Application No: FG/57/22/PL
Site Address: 12 Little Paddocks Ferring BN12 5NJ
Description of works: Demolition and erection of 1 No new dwelling. This application is in CIL Zone 4 and is CIL Liable as new dwelling.

Thank you for your internet representation made on 11th May 2022 which has been recorded as an objection with the comments as follows:

DRAWING No.
**Drawing 1
Existing & Proposed
Floor Plans & Elevations**

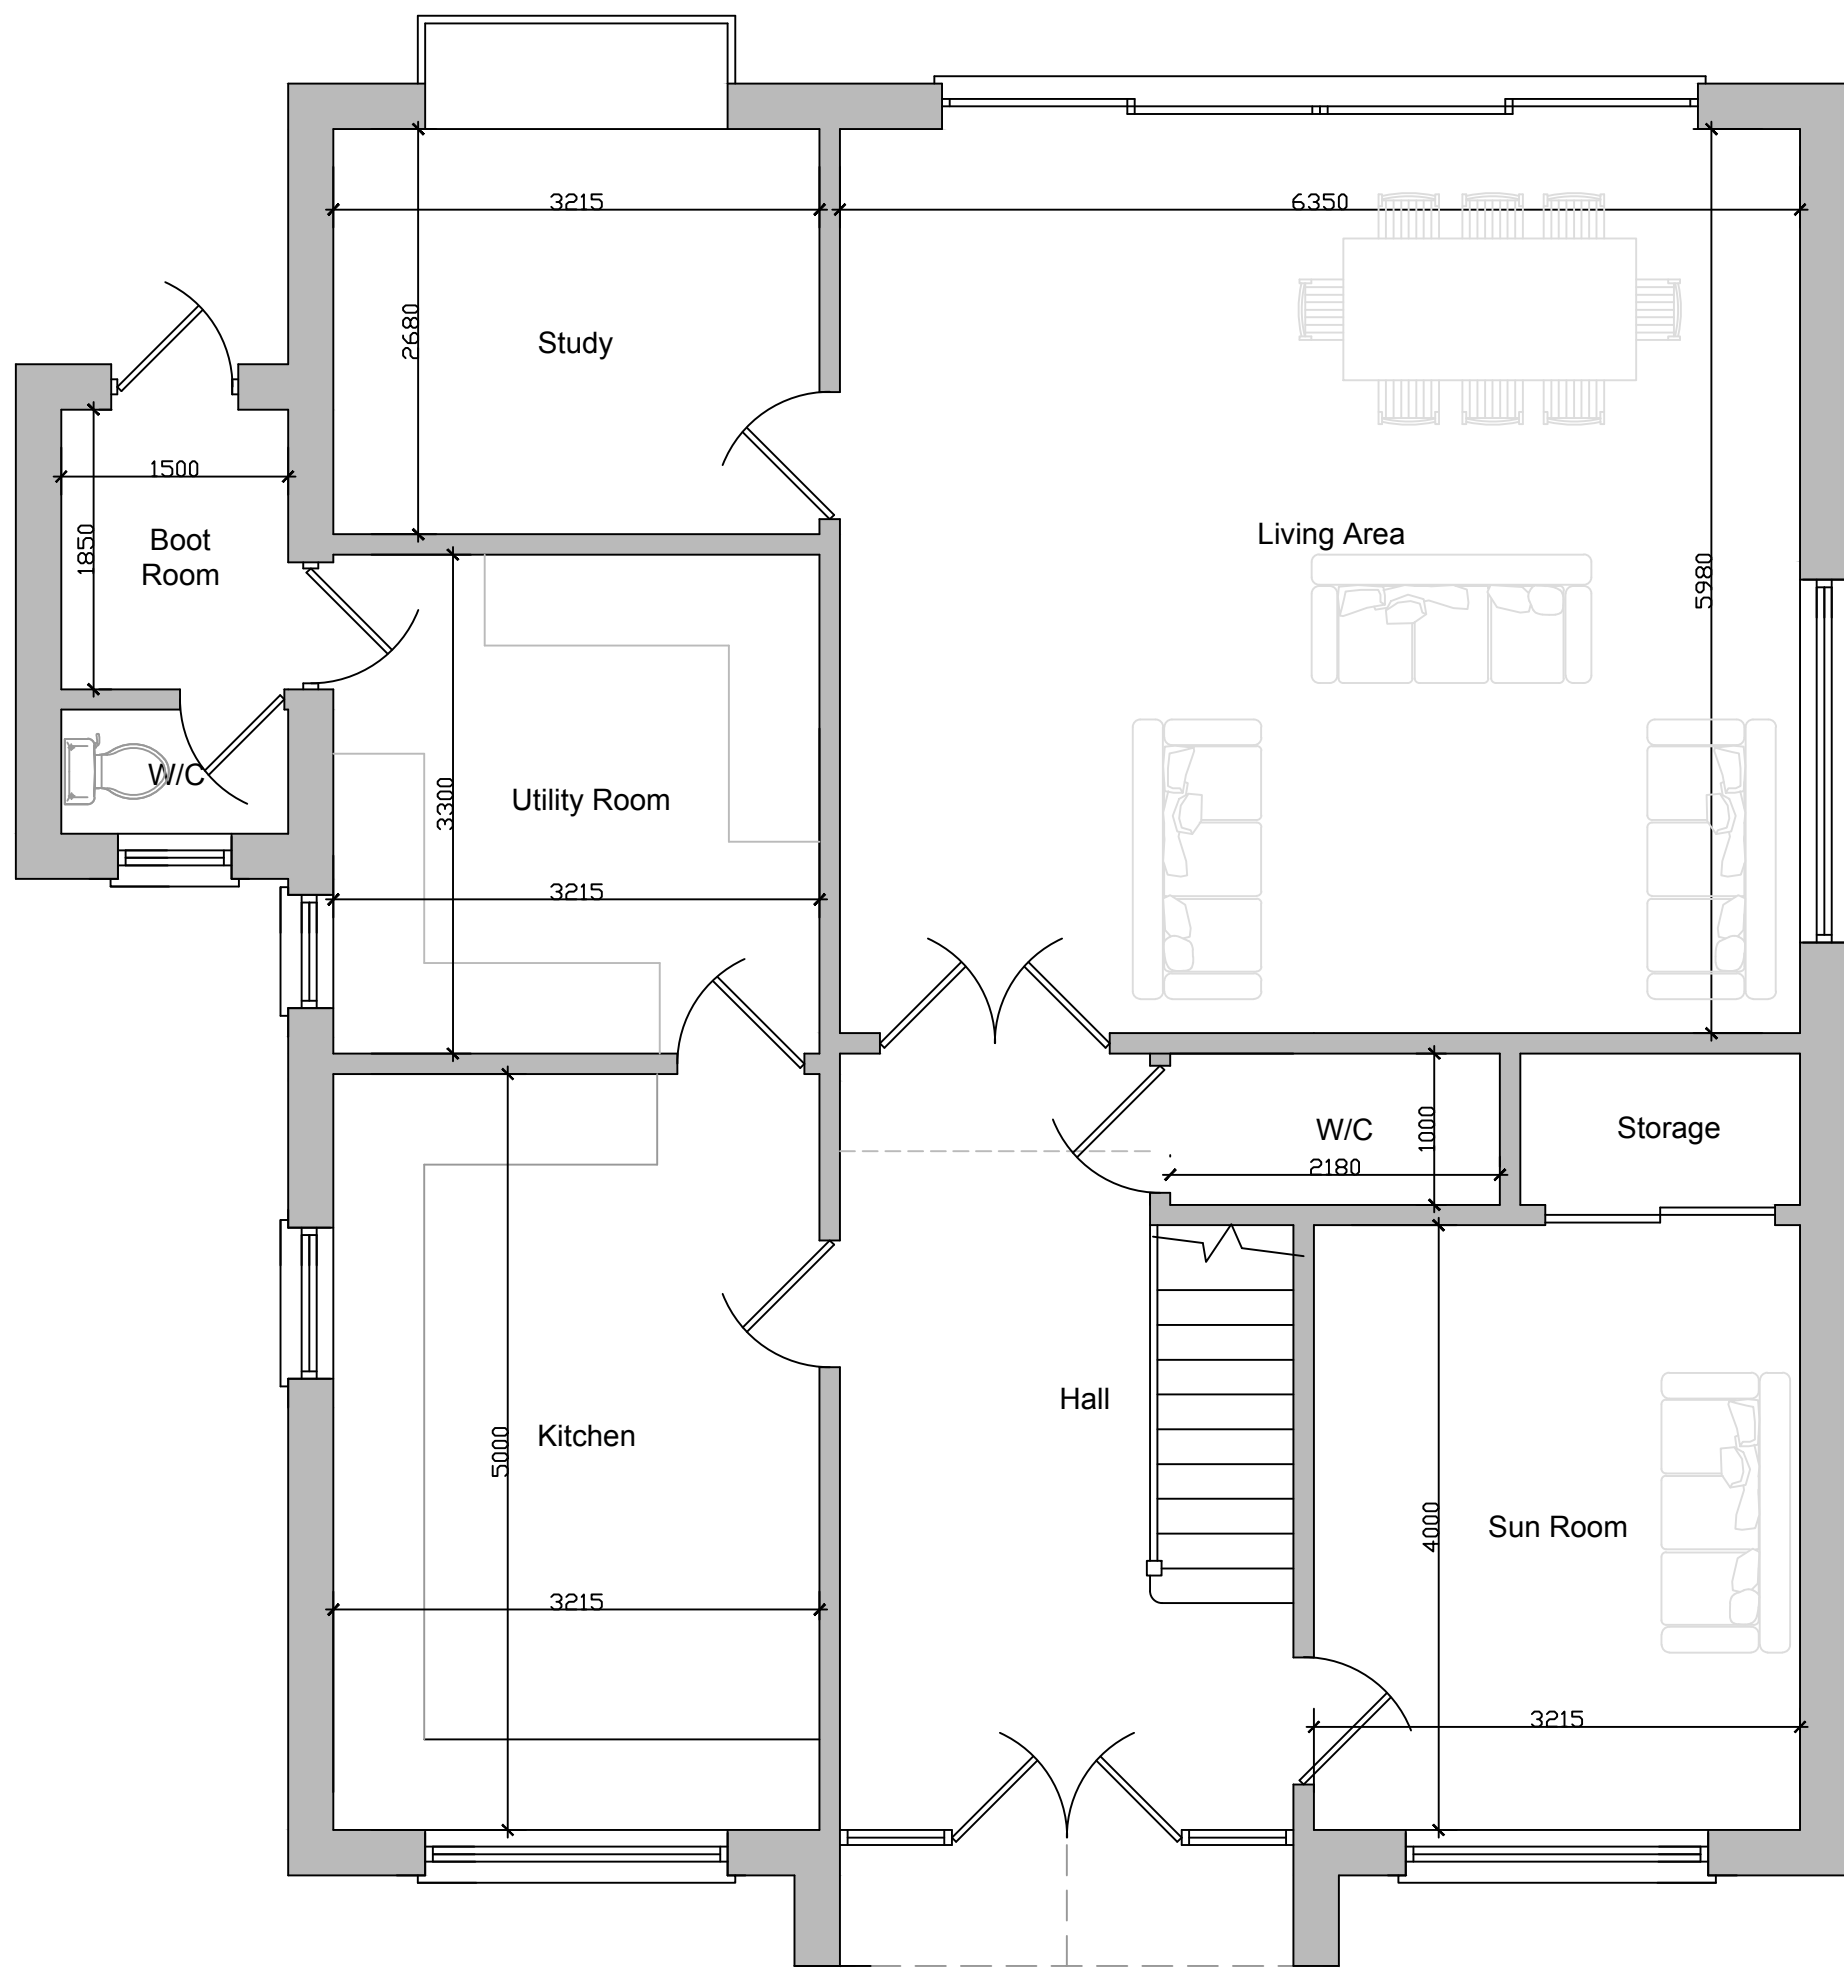
The proposed dwelling is completely out of character with other bungalows in the street scene. It will also overlook and overshadow the properties to either side of it and be overbearing. I understand that there is a restricted covenant on their deeds that says that any building or changes to a building must be approved by the Little Paddocks Shareholders and they have not given permission, making the build unlawful.
